SSD 8194
Z19/198100
DE-2017/22
18 September 2019

DENDROBIUM MINE EXTENSION PROJECT (AREAS 5 & 6)

WOLLONGONG CITY COUNCIL SUBMISSION – DENDROBIUM EXTENSION PROJECT

ILLAWARRA COAL
DENDROBIUM MINE - PLAN FOR THE FUTURE: COAL FOR STEELMAKING
BUILDINGS & OTHER STRUCTURES

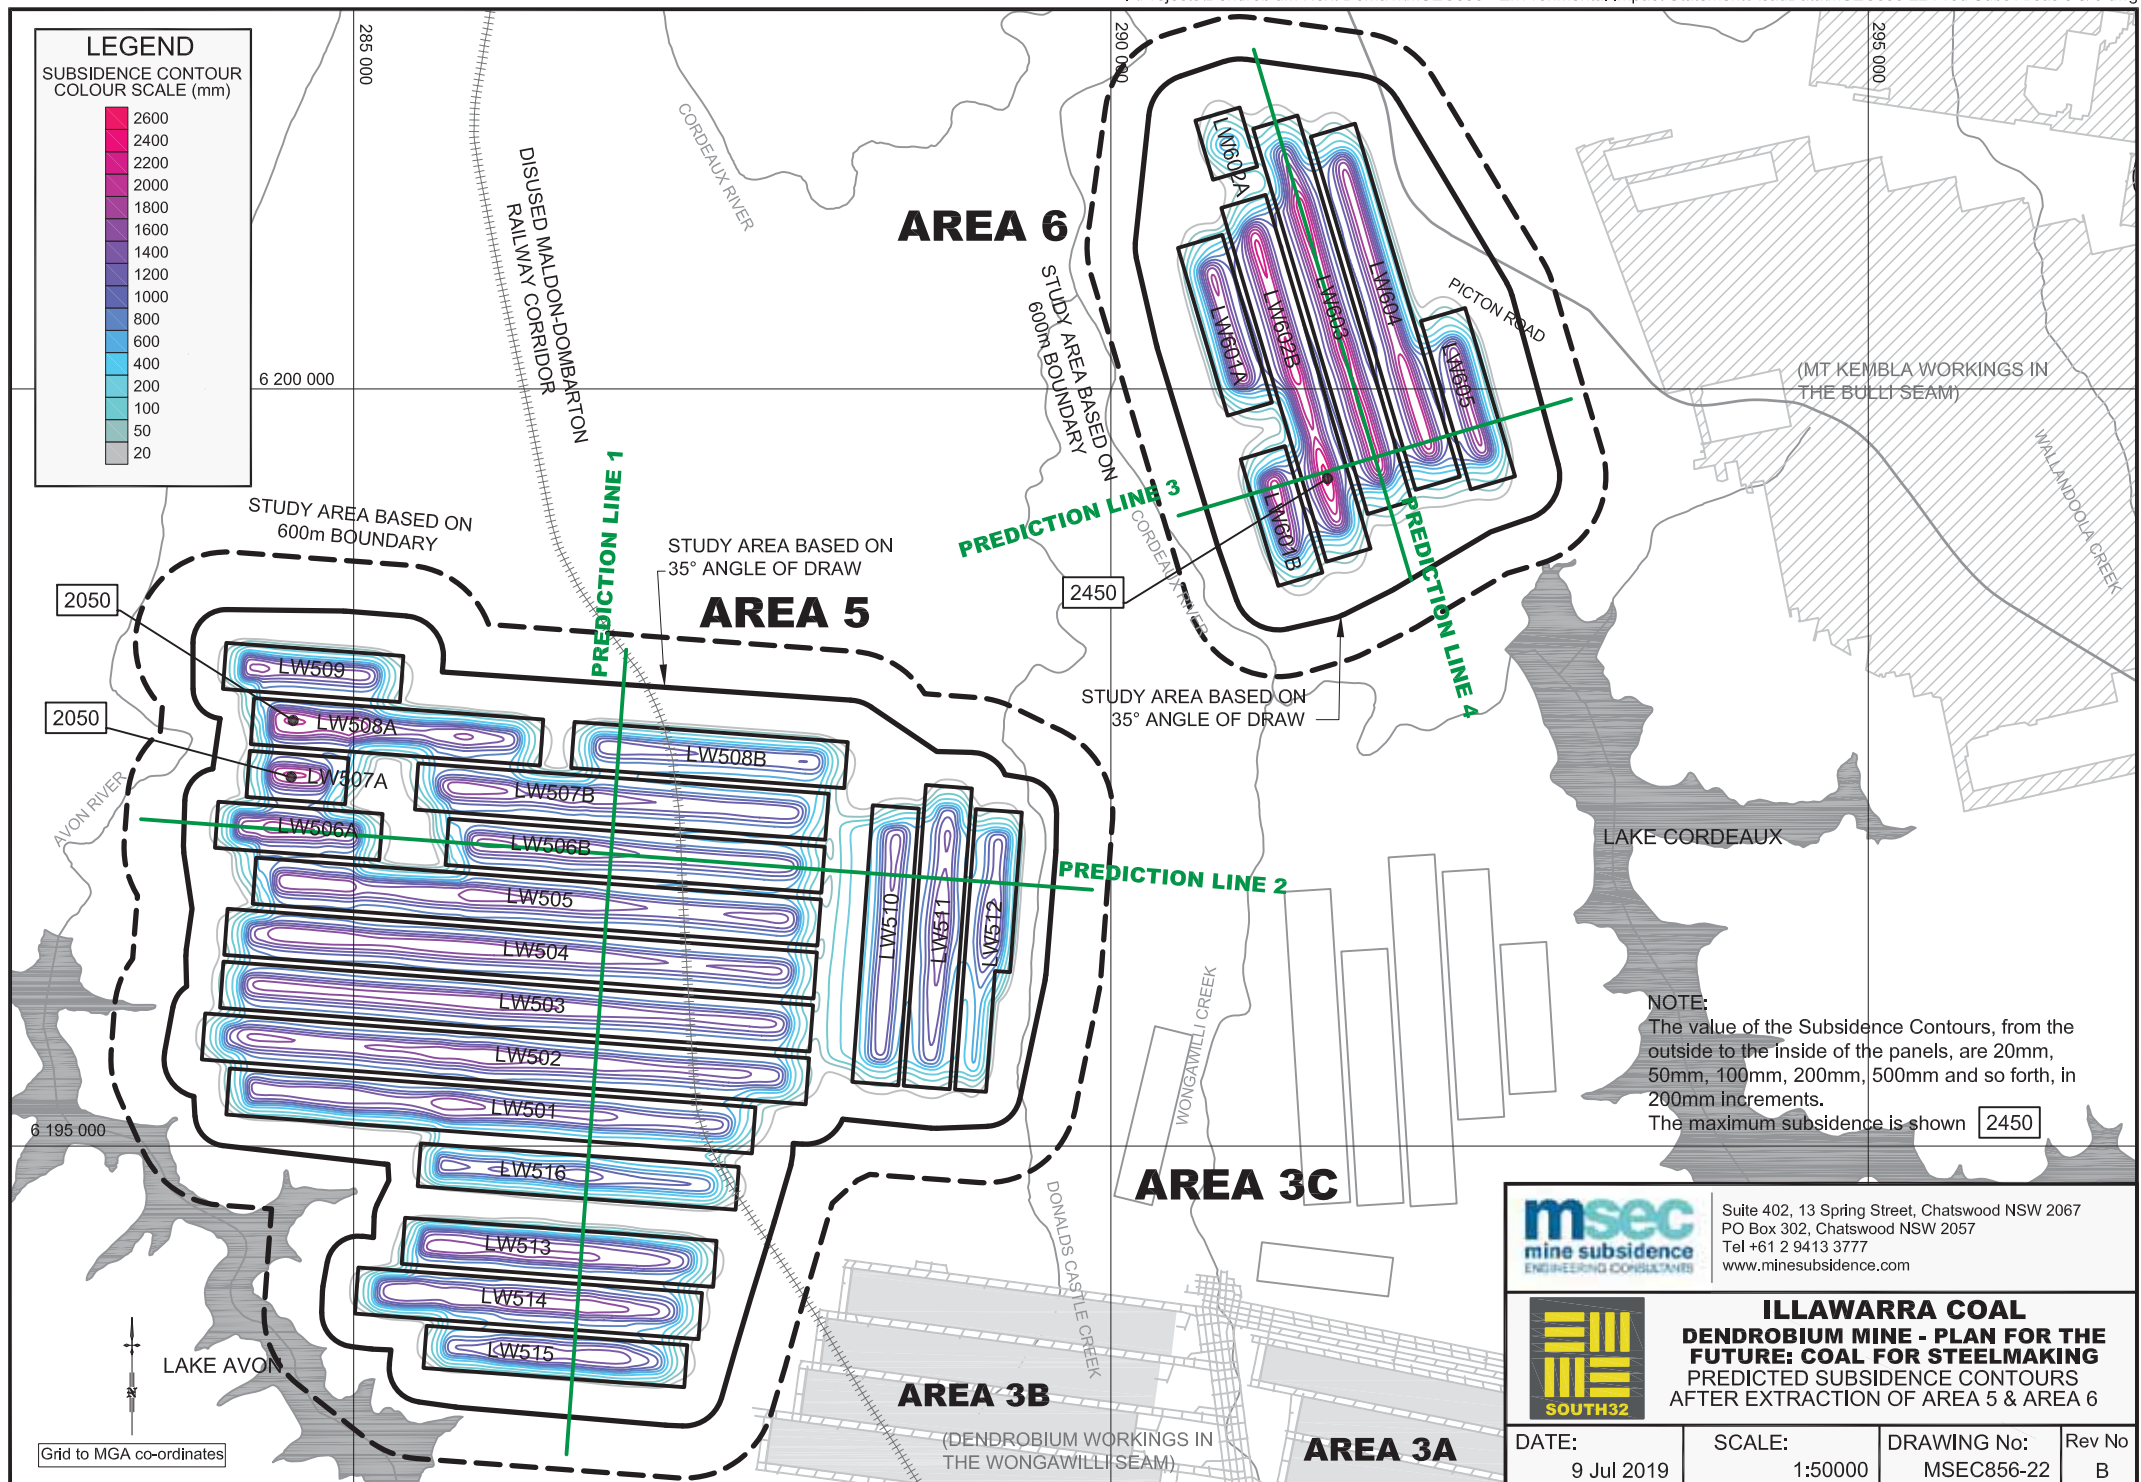
The proposed longwalls in Area 5 underlie the Maldon- Dombarton Rail Corridor.

In Council's view, the integrity of the Maldon-Dombarton Rail Corridor should be preserved. Therefore, Council requests that an appropriate management plan and monitoring program be developed to manage subsidence related impacts on the Maldon-Dombarton Rail Corridor, in consultation with the Australian Rail Track Corporation (ARTC).
